Application by Drax Power Limited for the Drax Bioenergy with Carbon Capture and Storage Project

The Examining Authority's written questions and requests for information (ExQ2)

The North Yorkshire Council's Responses

PROJECT:	DRAX BECCS DCO				
TITLE:	FIGURE 1 LANDSCAPE AND BIODIVERSITY MITIGATION PLAN

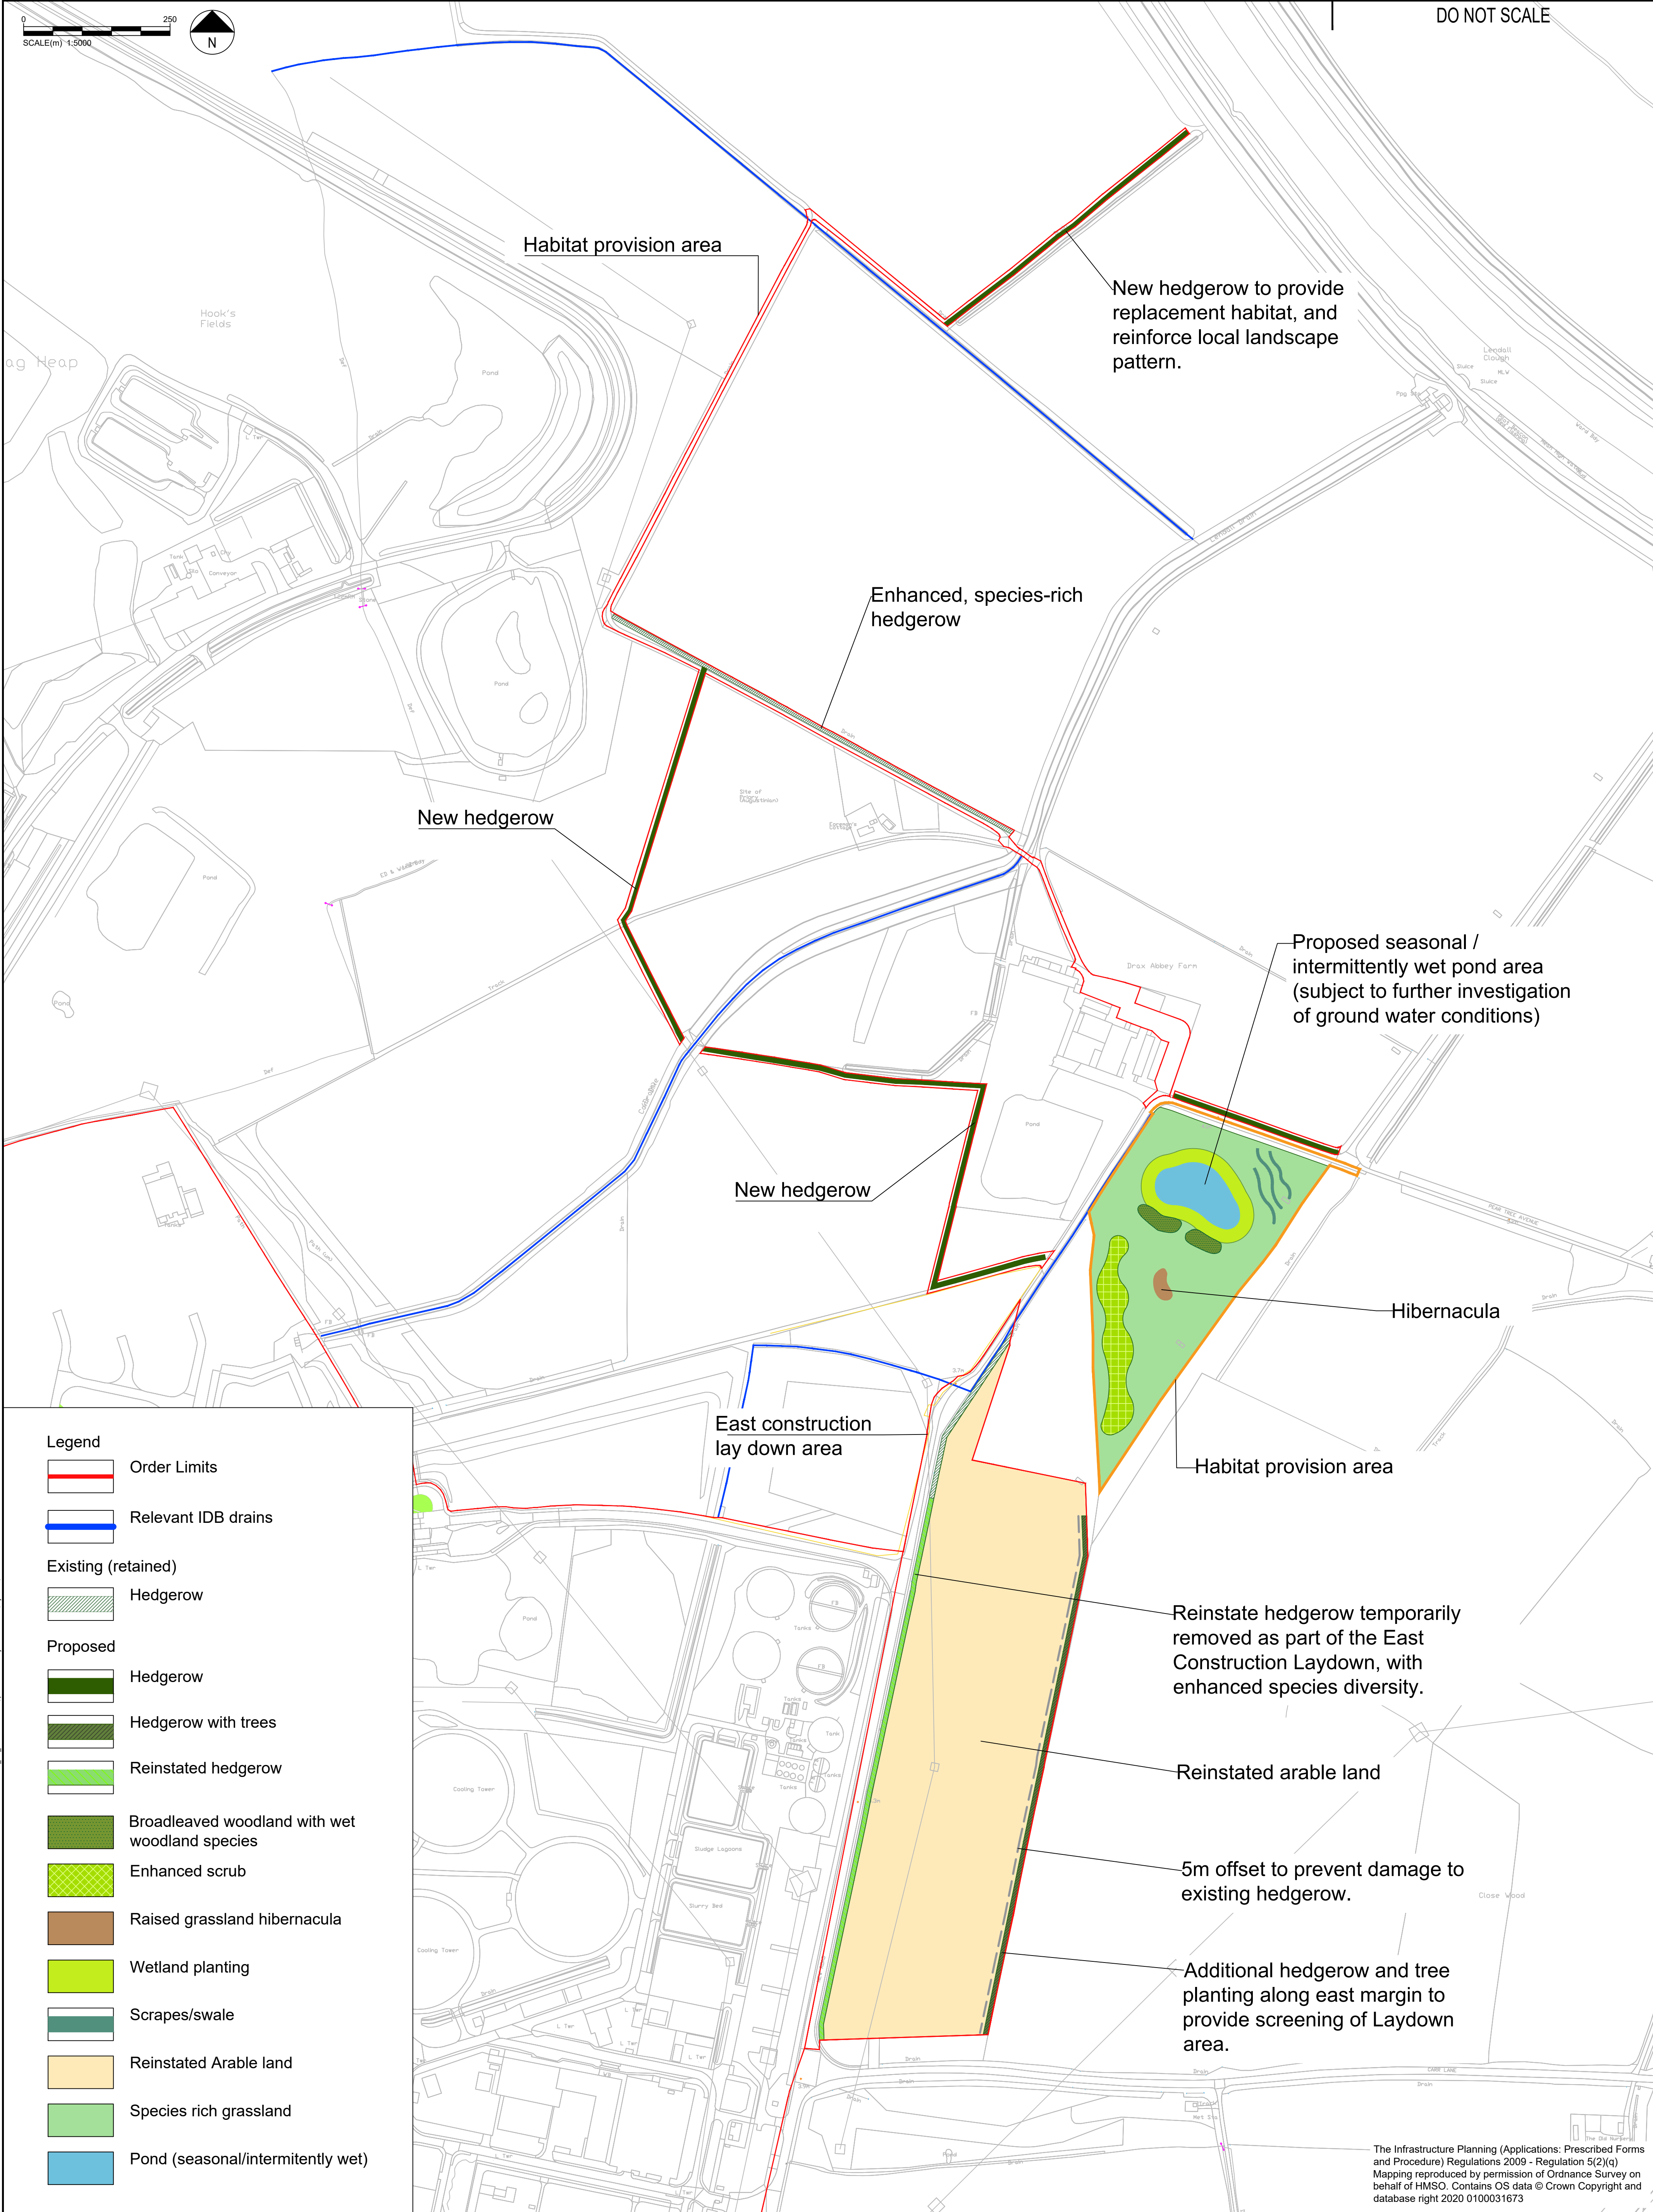
<ul style="list-style-type: none"> Improving the biodiversity value of amenity planting within the Power Station Site. 	
DLV.2.4	<p>NYC is asked to provide comments on the Applicant's updated OLBS [REP5-013] and the Applicant's Responses to Issues Raised at D4 [REP5-028] in relation to the concerns raised in its D4 submission [REP4-042], including whether its concerns on the following matters have been addressed and if not, what information NYC requires to address these concerns:</p> <ol style="list-style-type: none"> Long-term Maintenance and Management of Landscape. Removal of existing vegetation. Protection of existing trees. The landscape mitigation plan for works other than the habitat provision area. 	<p>The Authority is much happier with the revised OLBS as drafted. There are two points that the Applicant has been asked to clarify and consider. These are:</p> <p>That the ongoing maintenance requirements relate to both existing landscape features and vegetation within the Works areas and not just new vegetation.</p> <p>That the details of the lighting design to be submitted for approval by NYC will be of sufficient detail to allow the Authority to sign off when it is submitted. The Applicant has committed to provide responses to those matters.</p>
